Re: DAV Building (H19-D23)

Re: DAV Building (H-19-D23) Dated - 12/17/82

DRAINAGE REPORT AND DRAINAGE PLAN CHECKLIST

TITLE: ALLEY GRADES FOR ALLEY NORTH OF
MENAUL BETWEEN TEXAS AND UTAH, N.E.

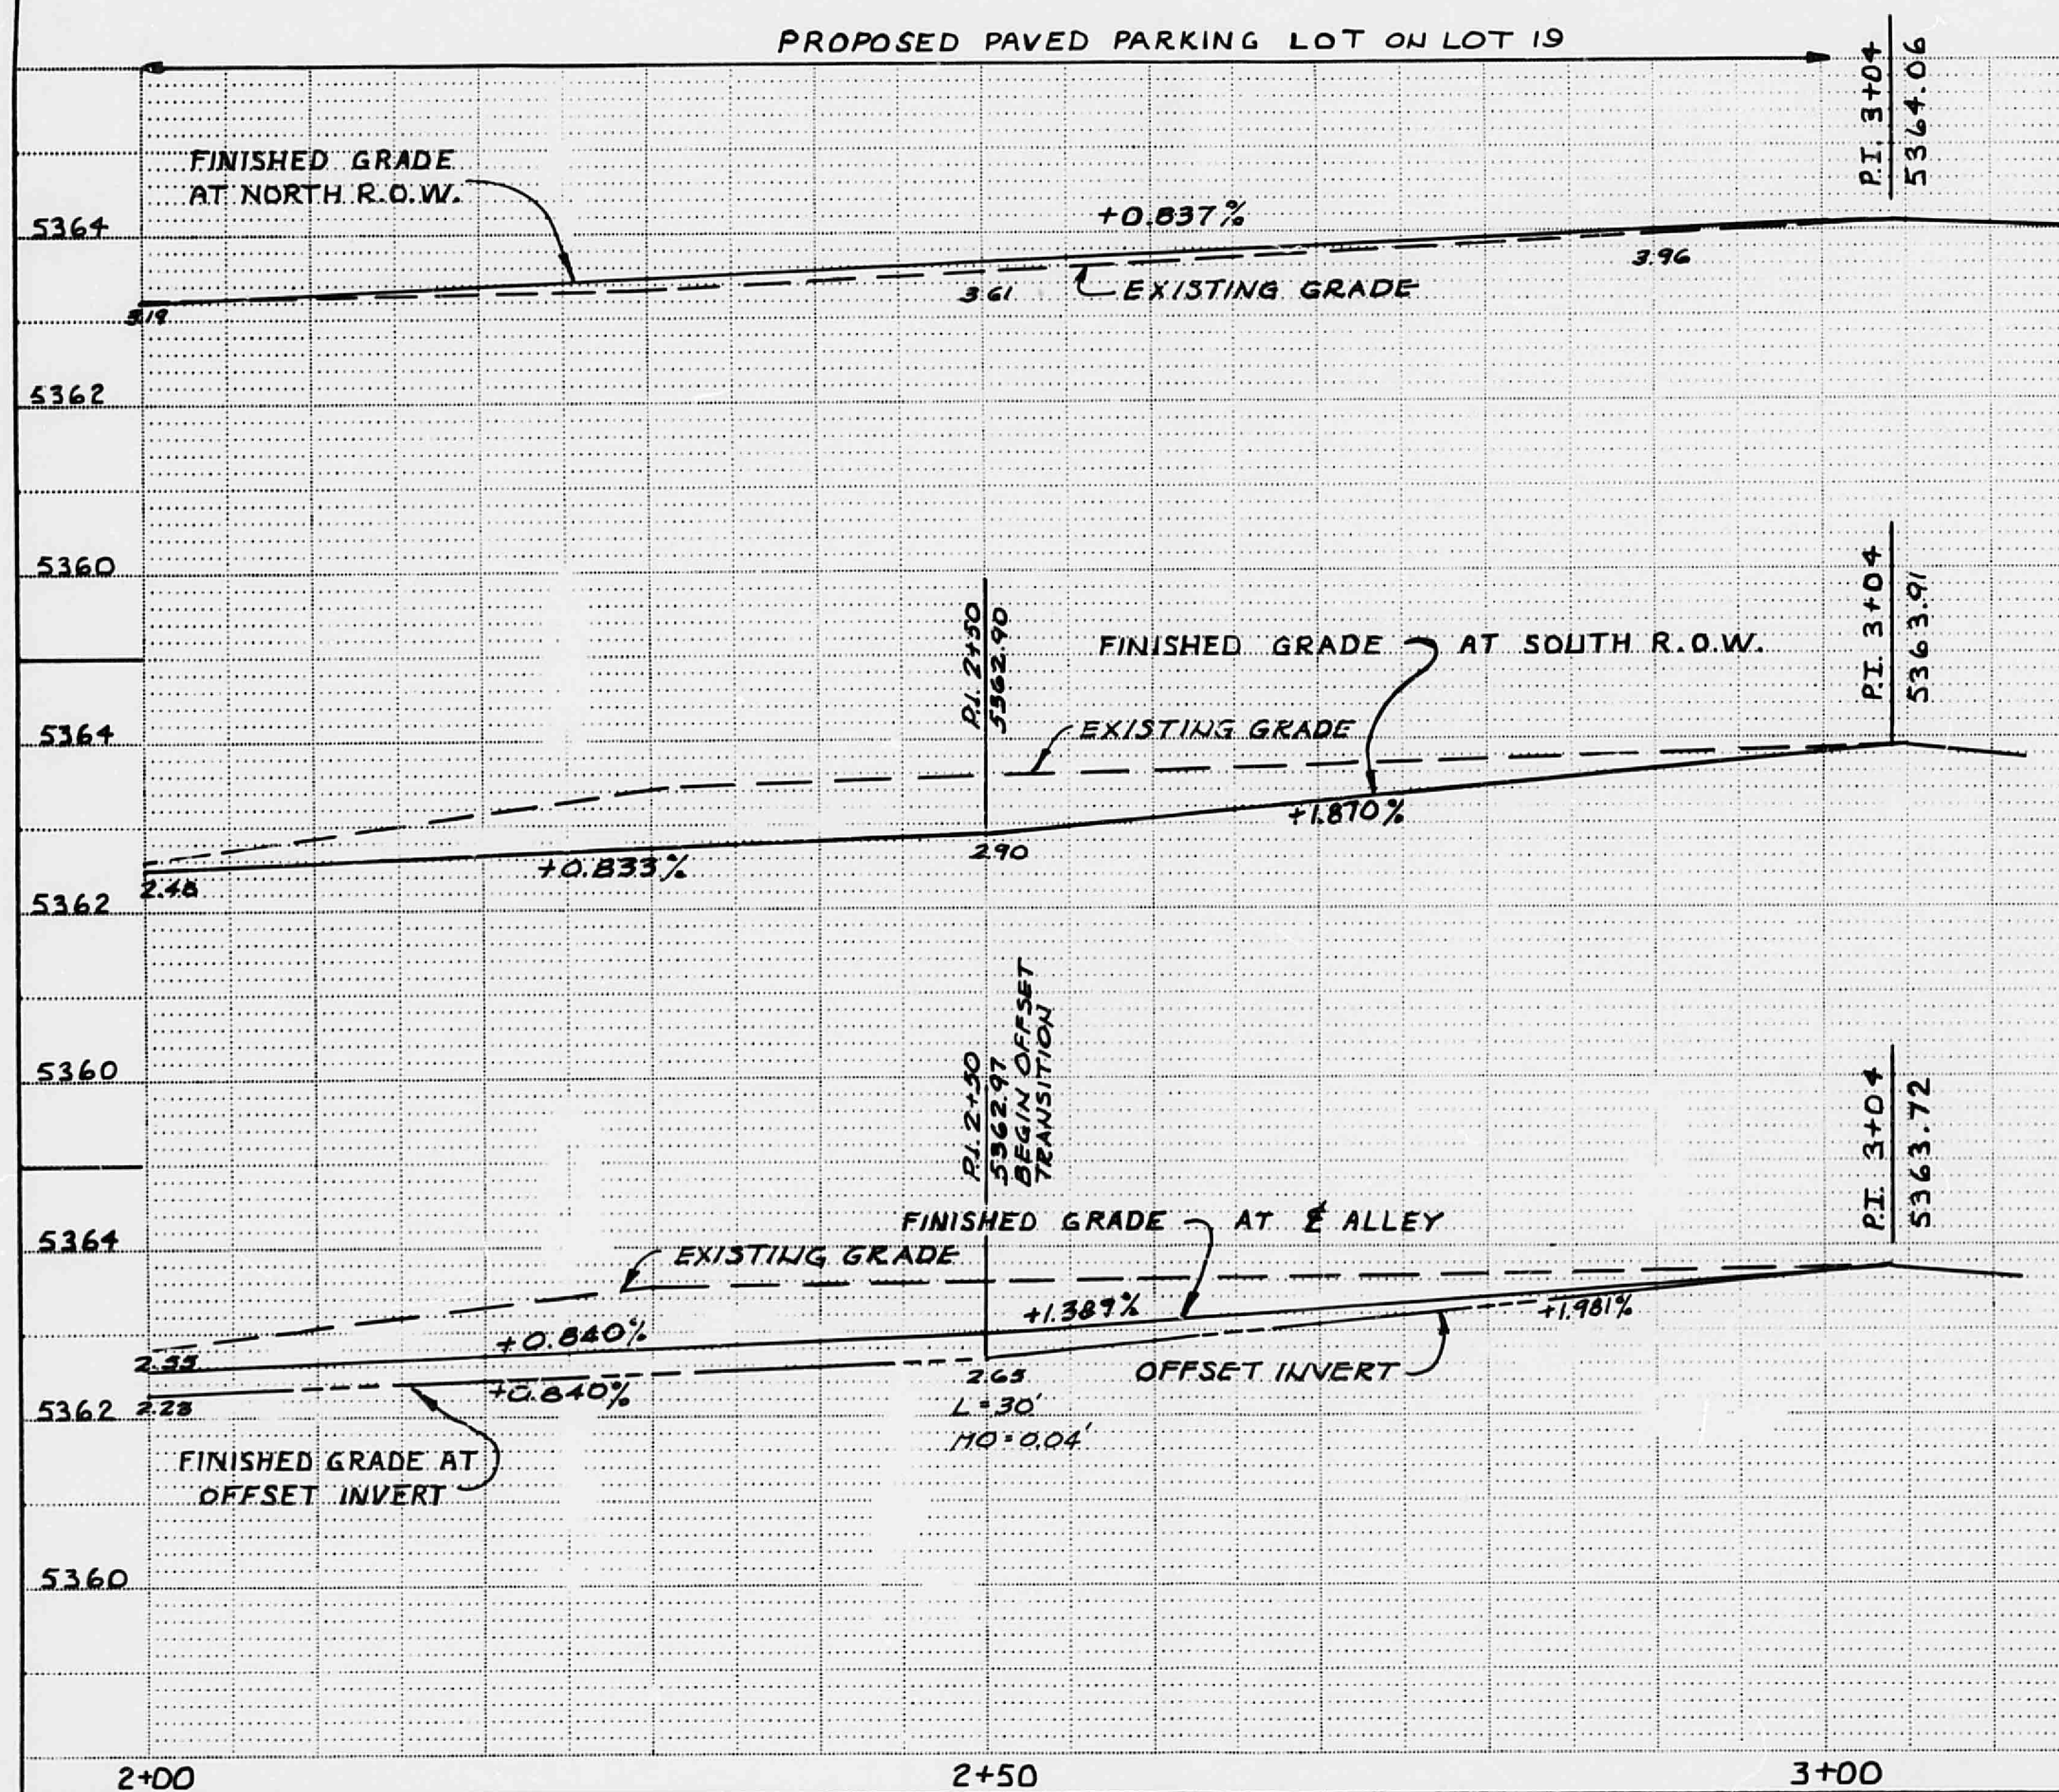
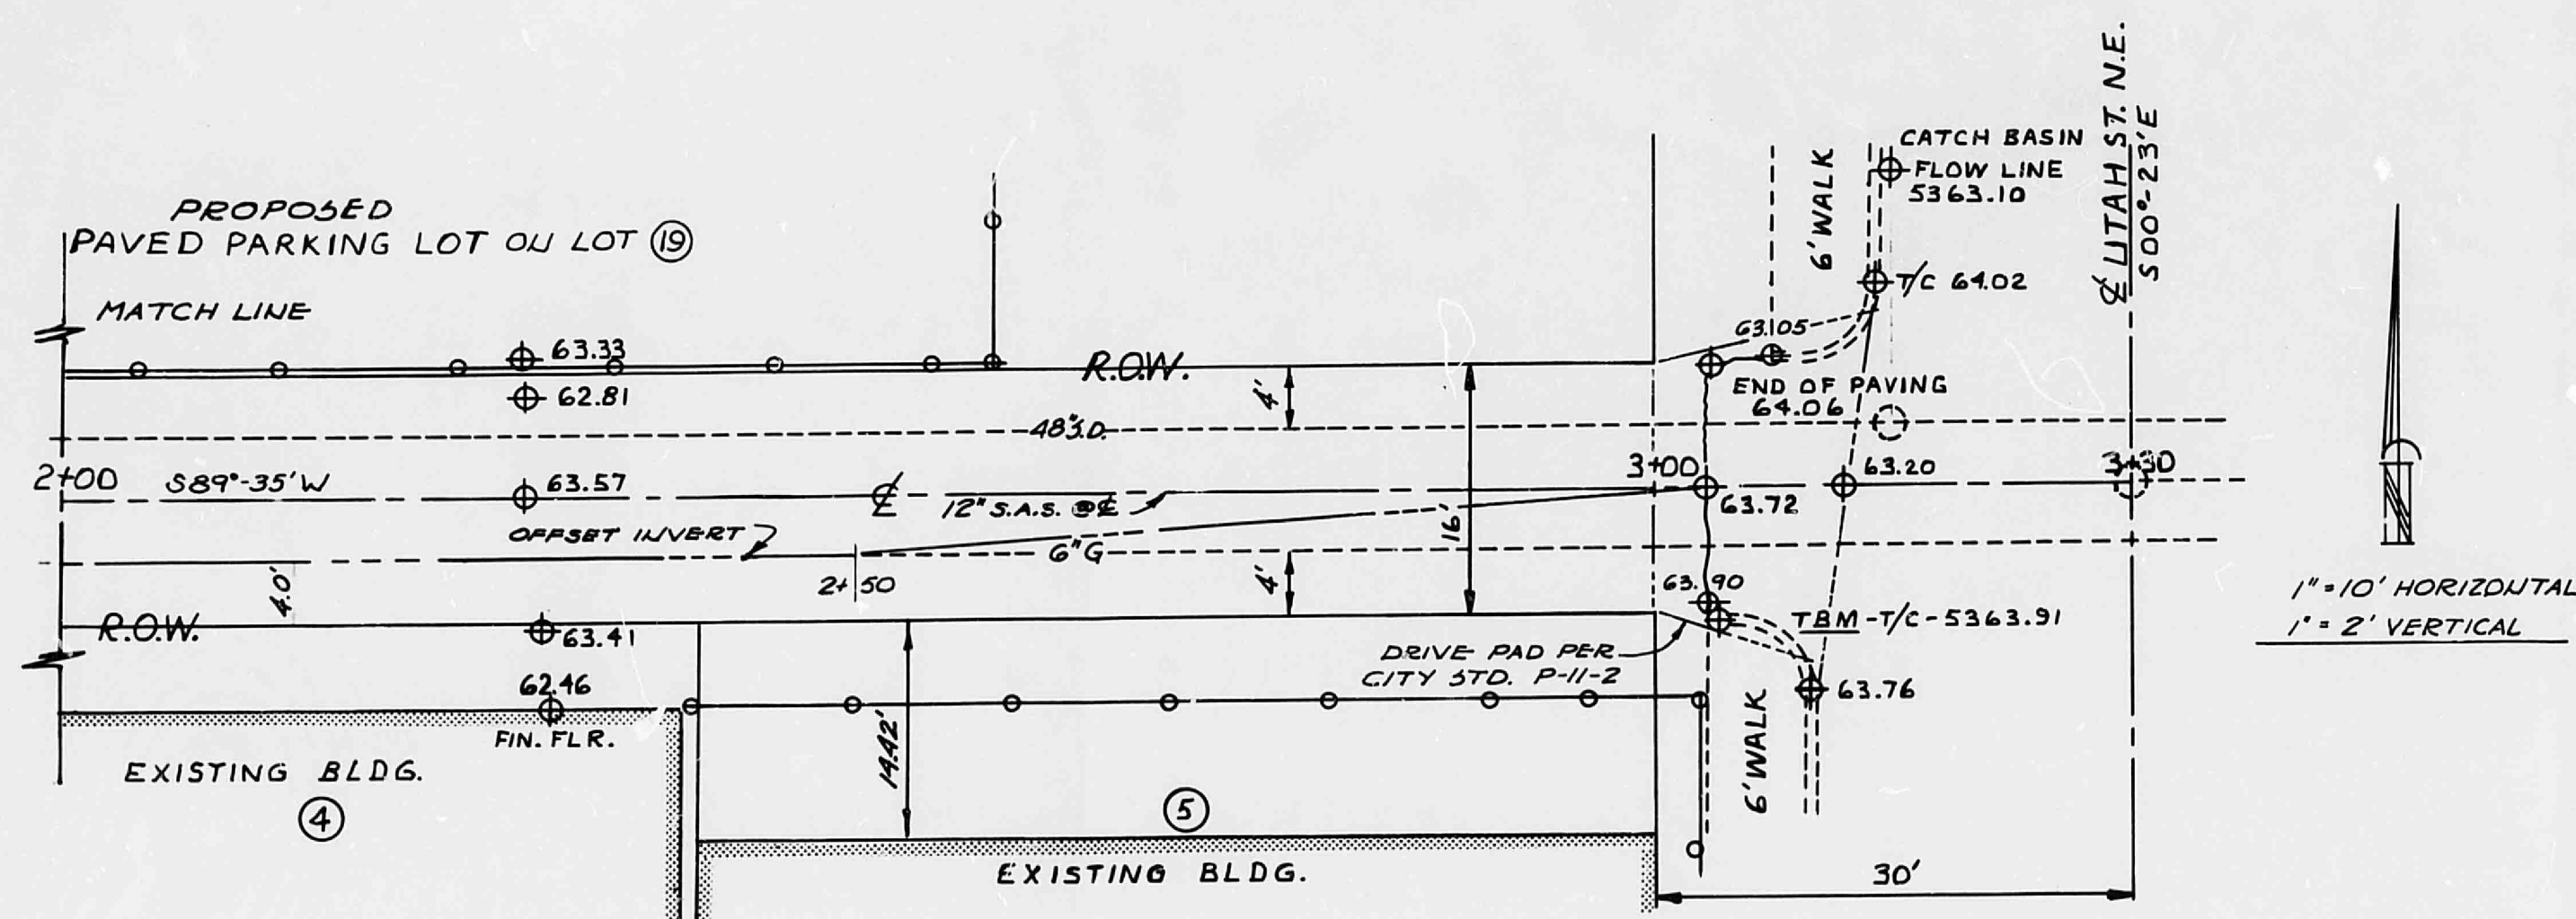
The referenced drainage plan is approved contingent on the acceptance of the alley grades by the Design Section. A copy of the approved alley grades will be required before the building plans can be released.

FILE # 41 PROJECT DAY Drainage Plan - 2511 Utah, NE

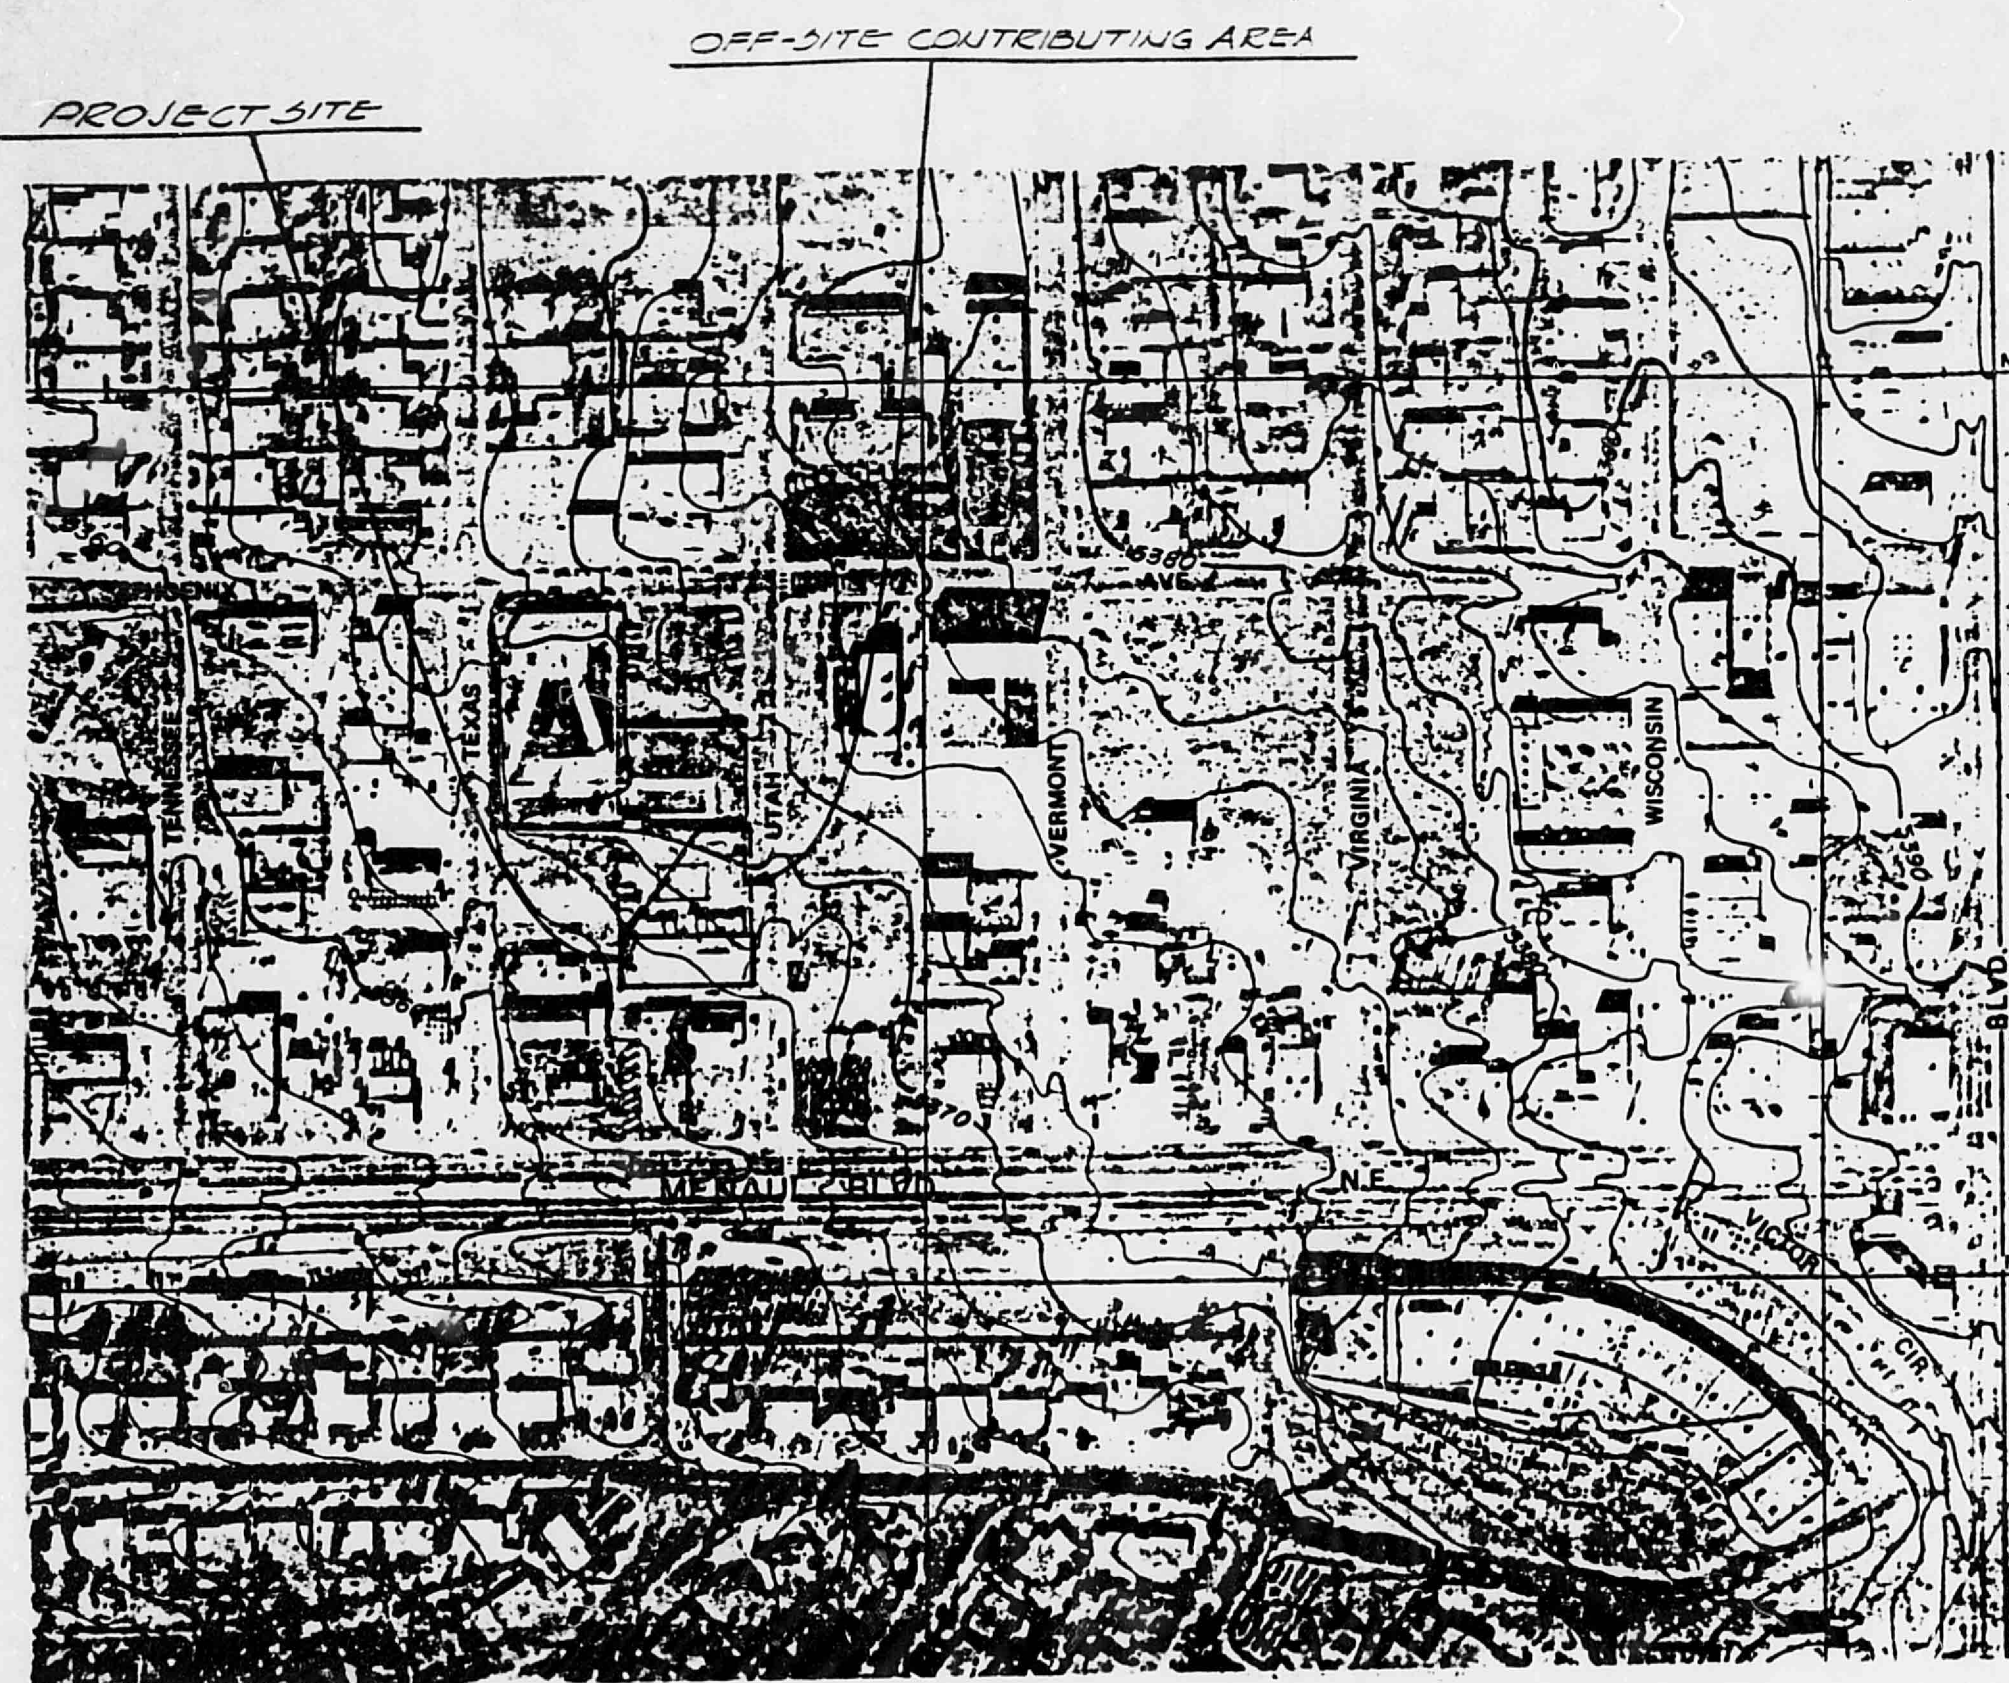
COMMENTS: Item 2. - Were there any drainage requirements with the approval of the existing building shown on the plan? Item 13.A. - The proposed plan to block

off-site is not acceptable. These flows must be accommodated within the property limits and routed to the City R/W. Item 13.C. and 17.B. - Address the adequacy

of the unimproved alley to convey the proposed storm runoff with respect to erosion and existing drainage pattern. Item 15, 17.A.1.&2. - Unable to follow the calculations provided for the required pond volume. Provide units and reference the values used in the calculations.

Note: The ponding requirements are not based on the difference between the developed and undeveloped flow rate but is based on the allowable discharge rate from the developed site.
